Application by Thames Water Utilities Limited for an Order Granting Development Consent for the Thames Tideway Tunnel

Examining authority's second written questions

Further to the letter from Jan Bessel dated 19 December 2013, ref WW010001, please find below written comments submitted on behalf of Transport for London, Unique Reference Number 10018167, in response to the following questions:

Book of plans - section 18
DCO-PP-16X-VCTEF-180008 - Rev 3
March 2014

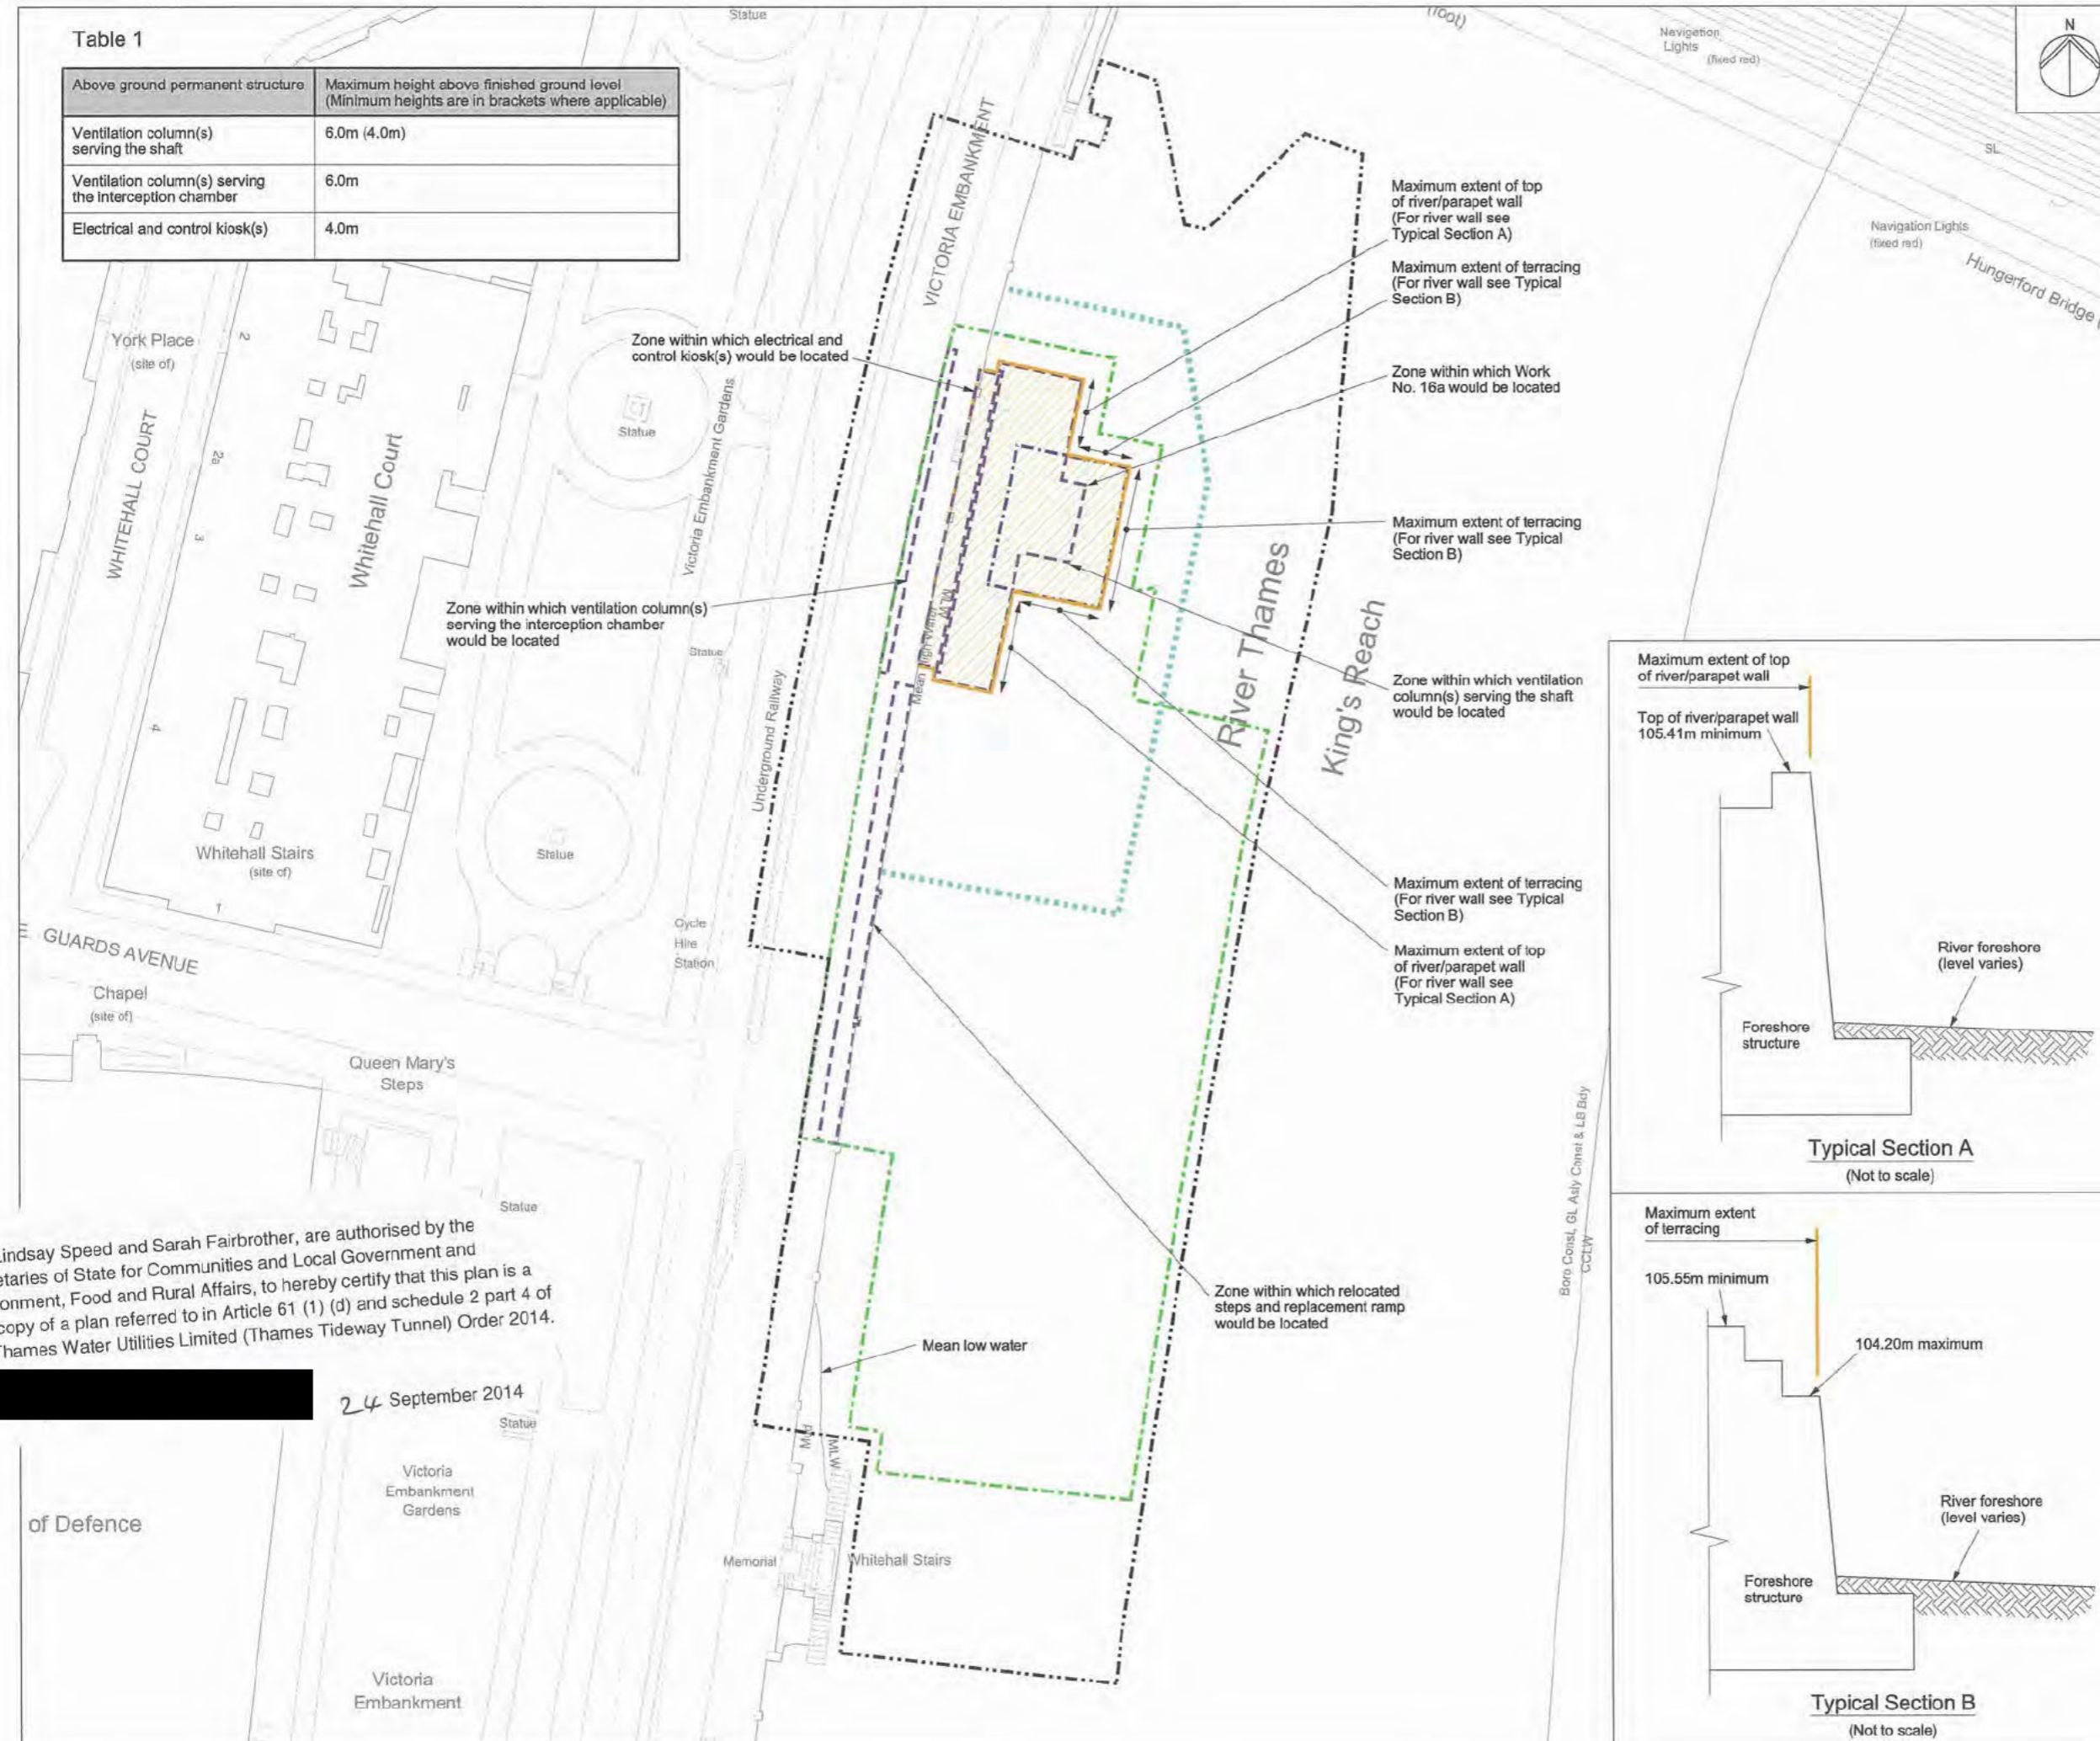
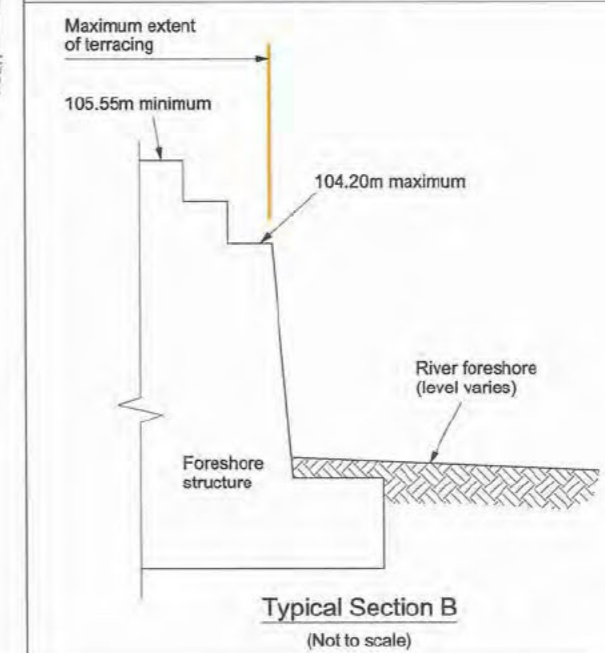
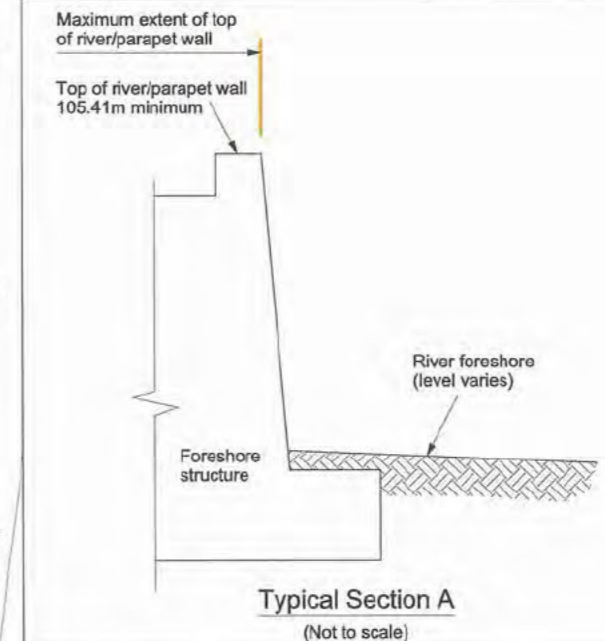
Q27.6	Question
	<p>Can the Applicant advise on the implications of reducing the heights of the ventilation columns at Putney Embankment Foreshore, Chelsea Embankment Foreshore, Albert Embankment Foreshore, Victoria Embankment Foreshore and Blackfriars Bridge Foreshore to 5.5m, as suggested by EH?</p> <p>Answer</p>

<p>This question is directed at TWUL, and TfL has also chosen to respond.</p> <p>TfL were present at a Chelsea Embankment Foreshore - Design Workshop on Tuesday 10th December. TWUL has subsequently circulated their design options for their proposal at this location, which TfL is currently considering.</p> <p>Note also that on 19 December 2013 TWUL issued a revised version of their <i>Design Principles</i> document seeking comments by the close of play on 31 December 2013 in advance of them submitting it to the Examining Authority on the 13 January 2014. Given the time of year and the availability of people to comment on the document, TfL has not yet responded to TWUL.</p> <p><i>However</i>, the point TfL wishes to make is that any proposals which affect TfL's assets, and / or our ability to discharge our duties as a highway and public transport authority, will need our full agreement. We will continue a dialogue with TWUL to help progress the TTT Project, whilst ensuring we adequately safeguard our interests.</p>
